R/285/19/HH - 17 Glenville Road Rustington (single storey rear extension)

With regard to the above project my client (in the spirit of being neighbourly) has instructed me to reduce the bulk of the extension located within the outrigger as indicated on the revised drawings 1934-03D and 1934-04D enclosed.

FRONT ELEVATION 1:50

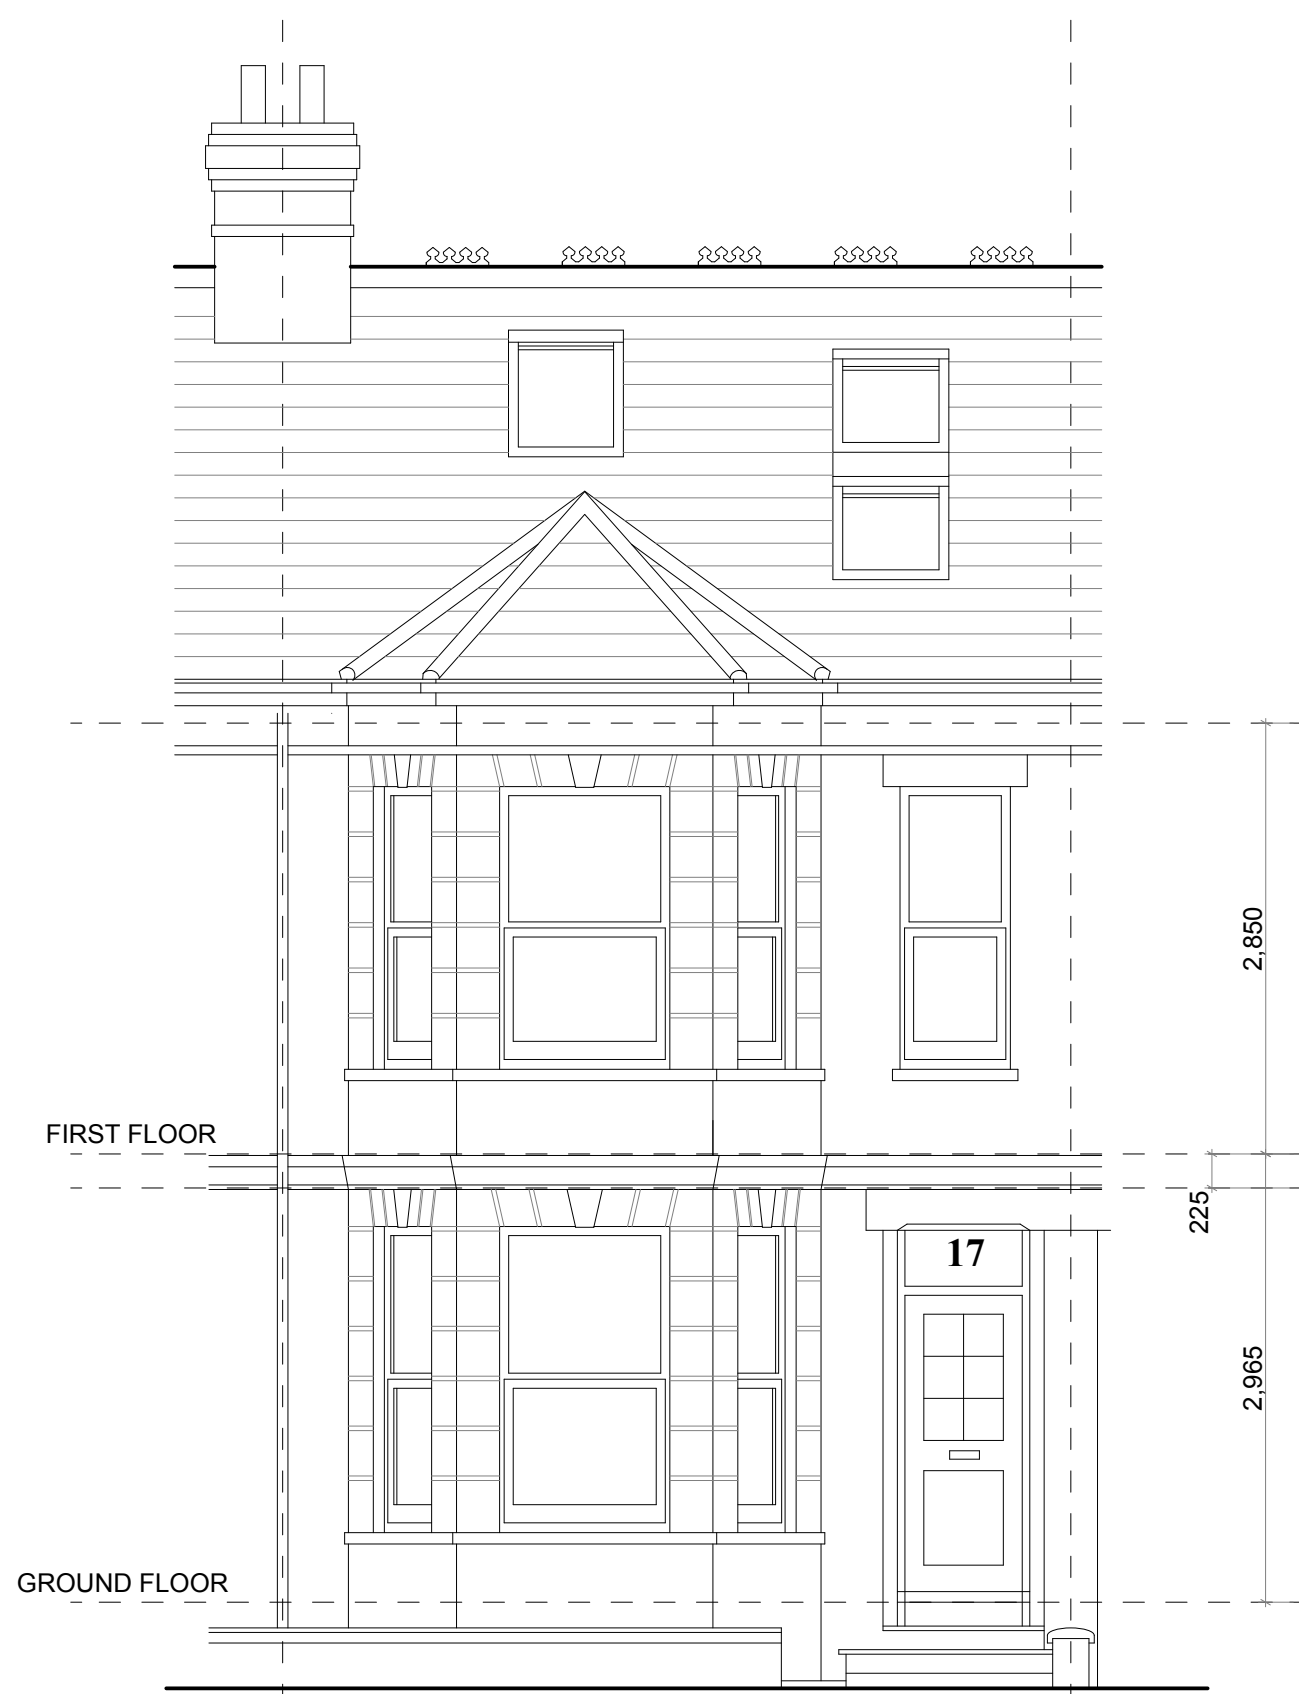
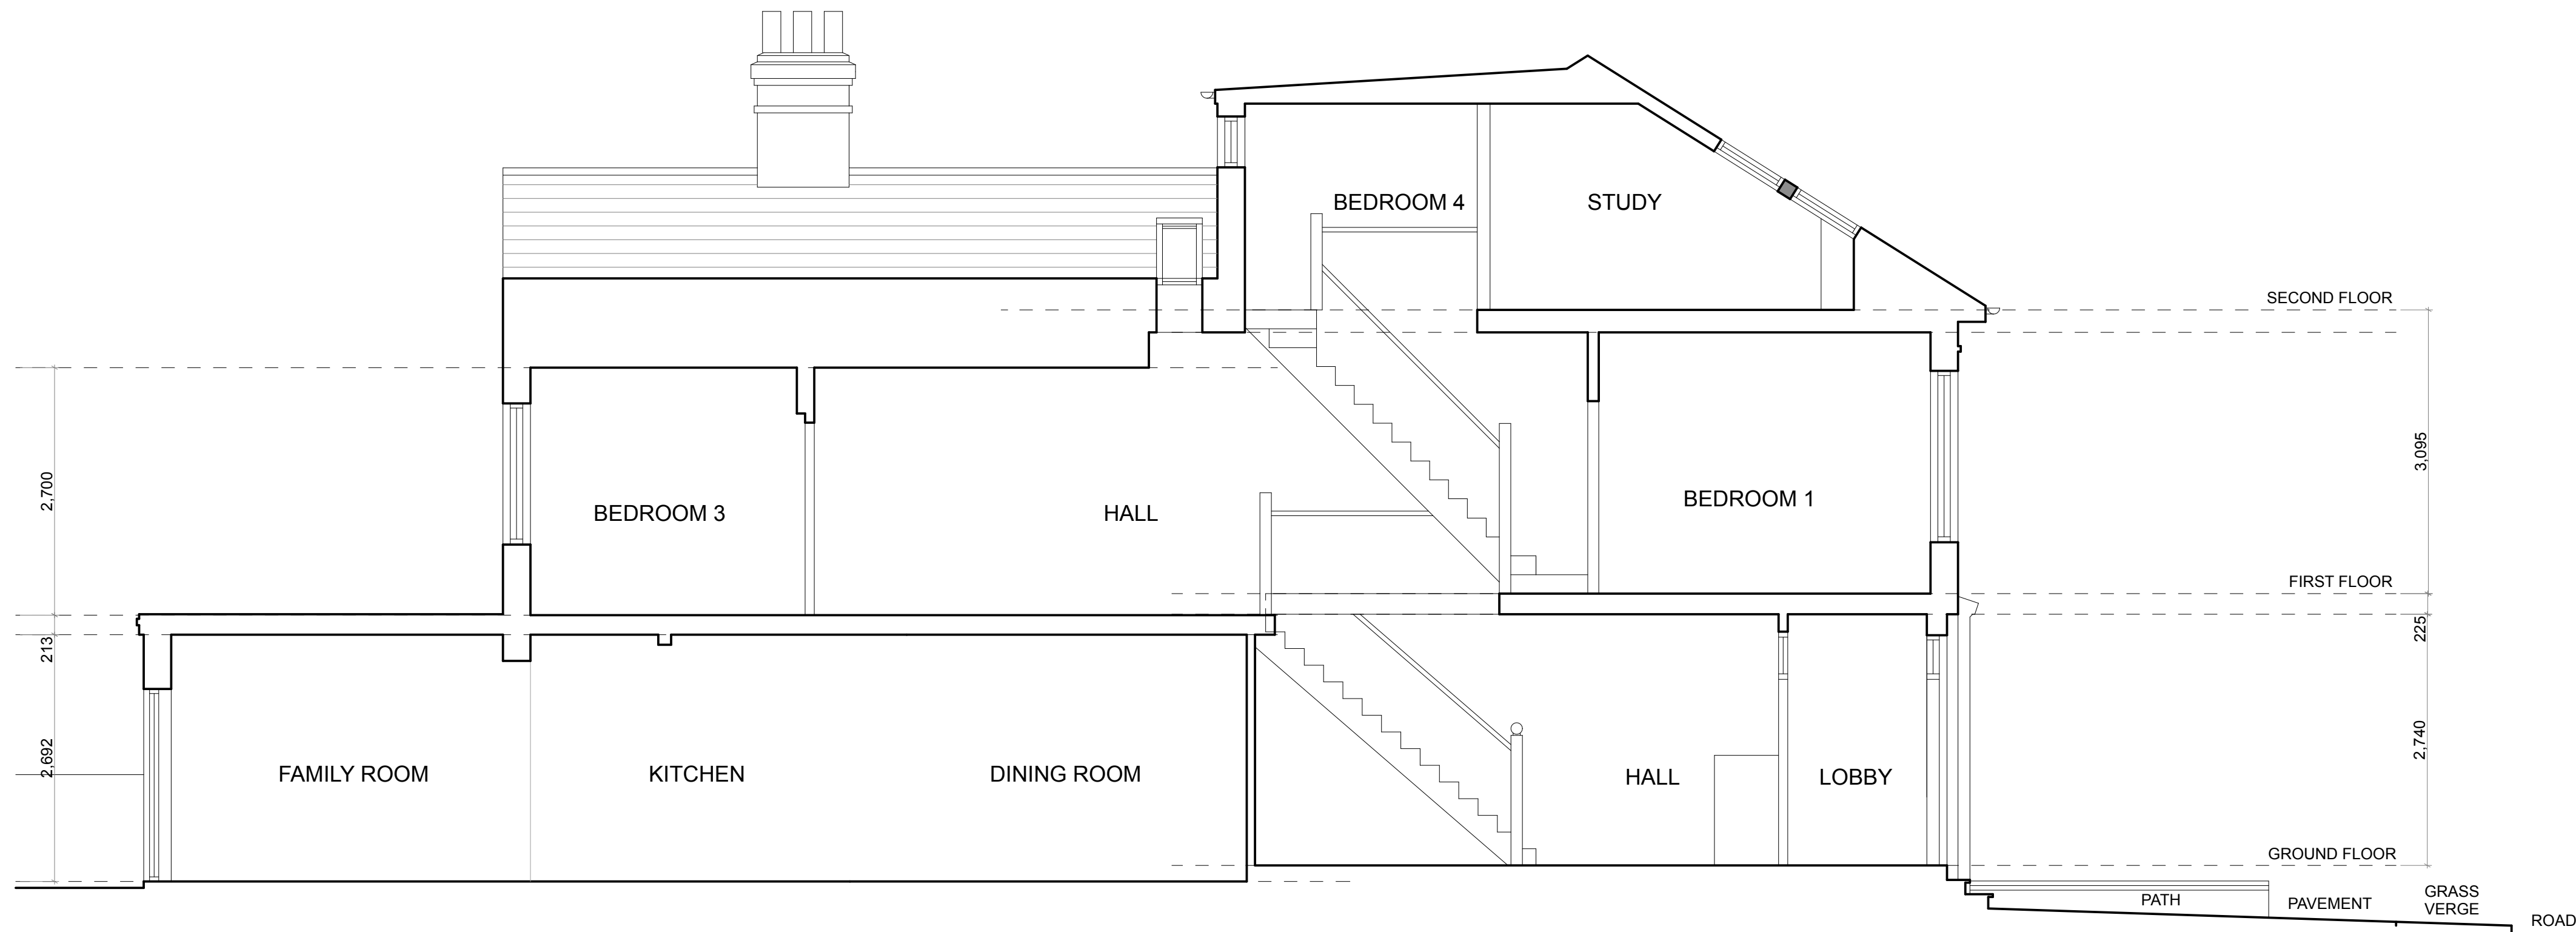
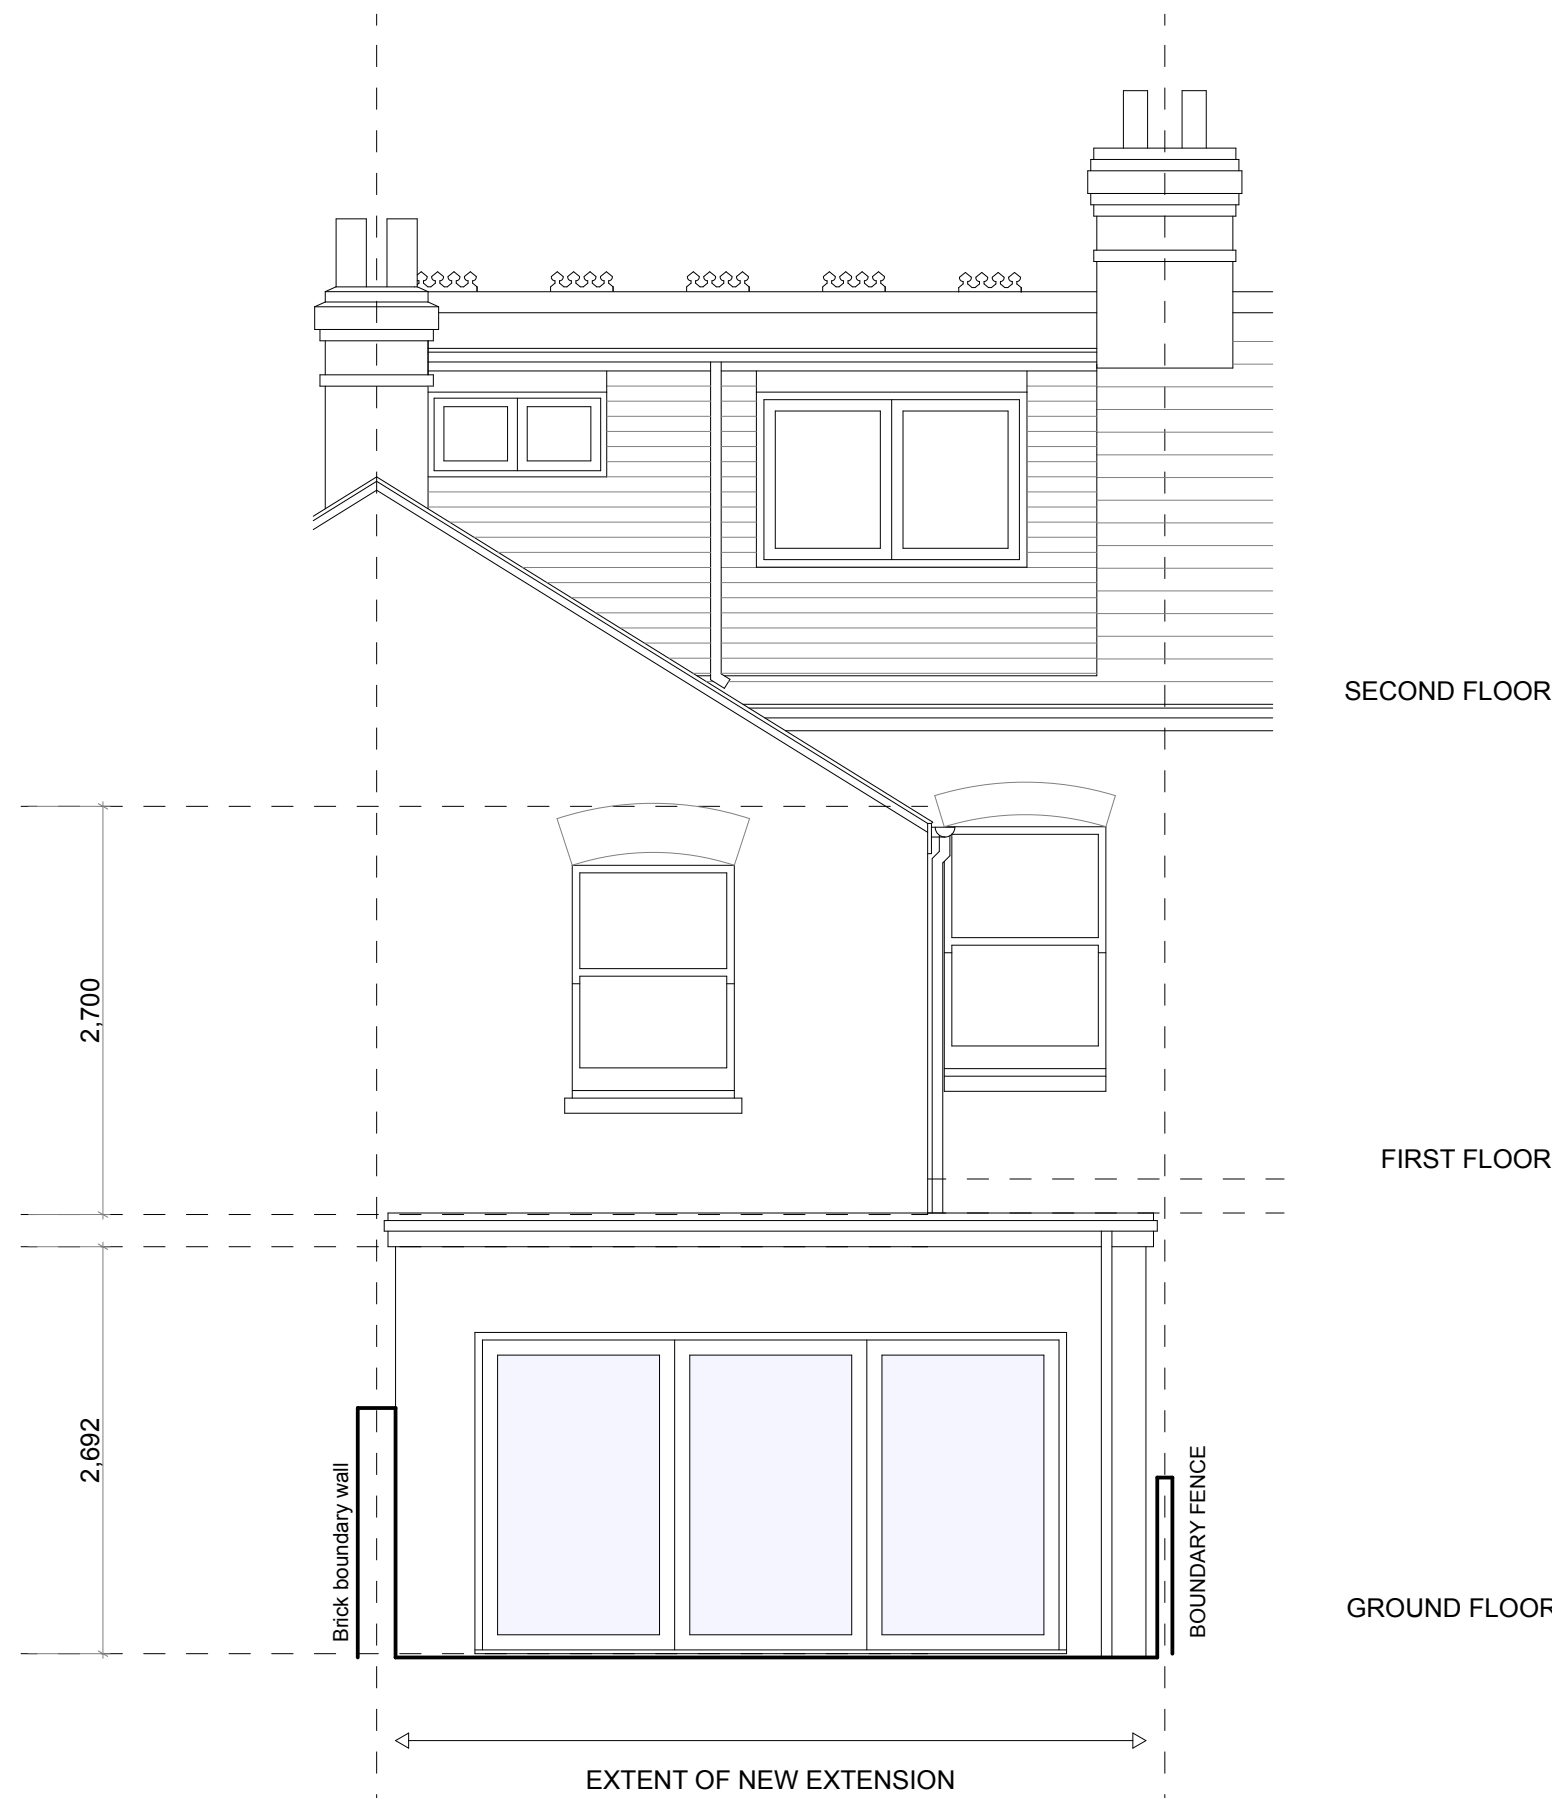
I like our neighbours and do not wish to upset the apple cart for a few extra feet. Is it possible to amend the plans so that the extension purely covers the back of the house and not down the side return?

The side door in the kitchen (leading out to the Courtyard) will remain blocked up as on the plans but both of the single windows will be re instated. Finally, could we have a fully glazed window/ door looking into/ down the Courtyard from the new extension.

Anyway – let me know your thoughts and any further comments.
Once I receive these I will also amend the elevations and block plan and formalise the revised drawings with the local authority.
